Application Ref:	2026/0240			 Ribble Valley Borough Council www.ribblevalley.gov.uk
Date Inspected:	22/05/2026	Site Notice:	22/05/2026	
Officer:	EP			
DELEGATED ITEM FILE REPORT:				APPROVAL

Development Description:	Proposed extension of the residential curtilage, demolitions to allow the construction of a two-storey side extension and single-storey rear extension including an attached garage with associated alterations.
Site Address/Location:	South Lodge Mitton Road Whalley BB7 9JN

SHEET:  
PROPOSED ELEVATIONS

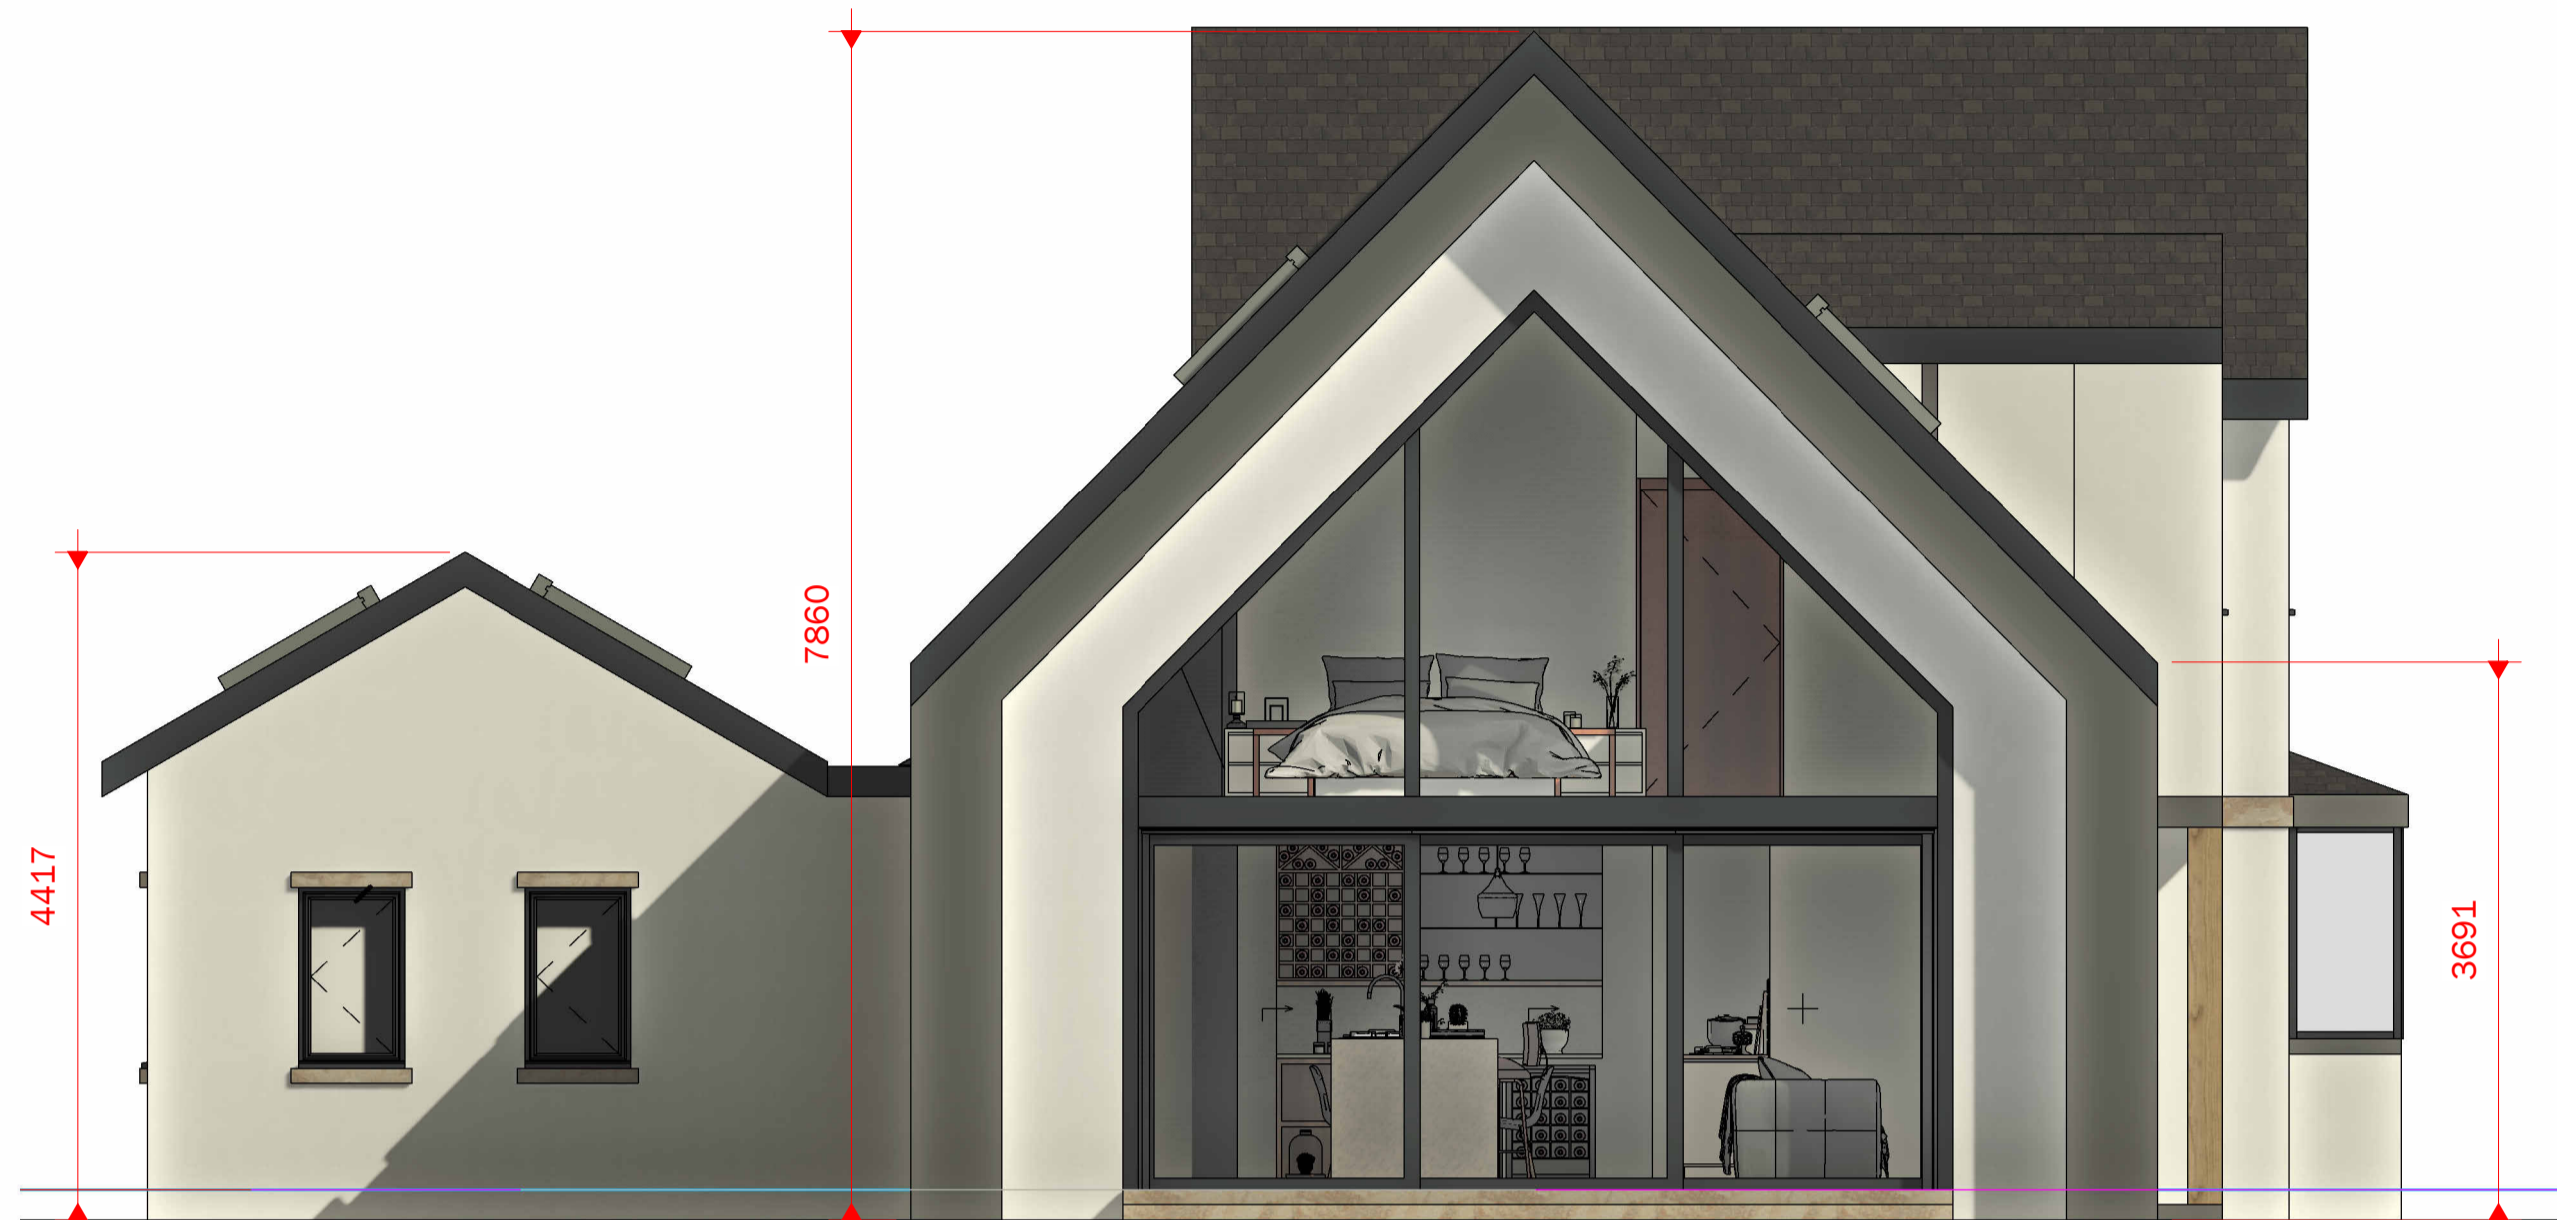
There are large sections of glazing proposed to the southern elevation of the extension. There is a sufficient distance of approximately 27m between the proposed glazing and neighbouring habitable windows/private amenity space to mitigate overlooking and loss of privacy. In addition, following discussion, the amount of glazing proposed has been reduced to manage any perception of overlooking.

The proposed two storey extension will be located to the eastern extent of the application dwelling adjoining the existing outrigger. Typically, for two storey extensions of this nature a 1m set back from the principle building line and a set down from the ridge is required. The proposed extension in this instance matches the ridge of the existing dwelling and sits flush with the principal and rear building lines of the host

dwelling. However, if a setback/set down were to be executed, it would create a tiered effected, which given the varying roof pitches and outriggers present at the existing dwelling, would result in the property appearing overdeveloped. The application dwelling is a standalone property and does to sit uniformly with any of its neighbours. As such, the lack of setback is considered acceptable in this instance.

The existing property comprises rough cast render and facing brickwork to the elevations, with a tiled roof profile and timber windows and doors. The proposed property once developed would be faced entirely in render, with cladded and stone feature elements. Whilst more contemporary in design compared to the existing dwelling, there are varying types of development in the immediate vicinity which are comparable to the proposal. As such, it is not considered the development would be of harm to the character of the area.
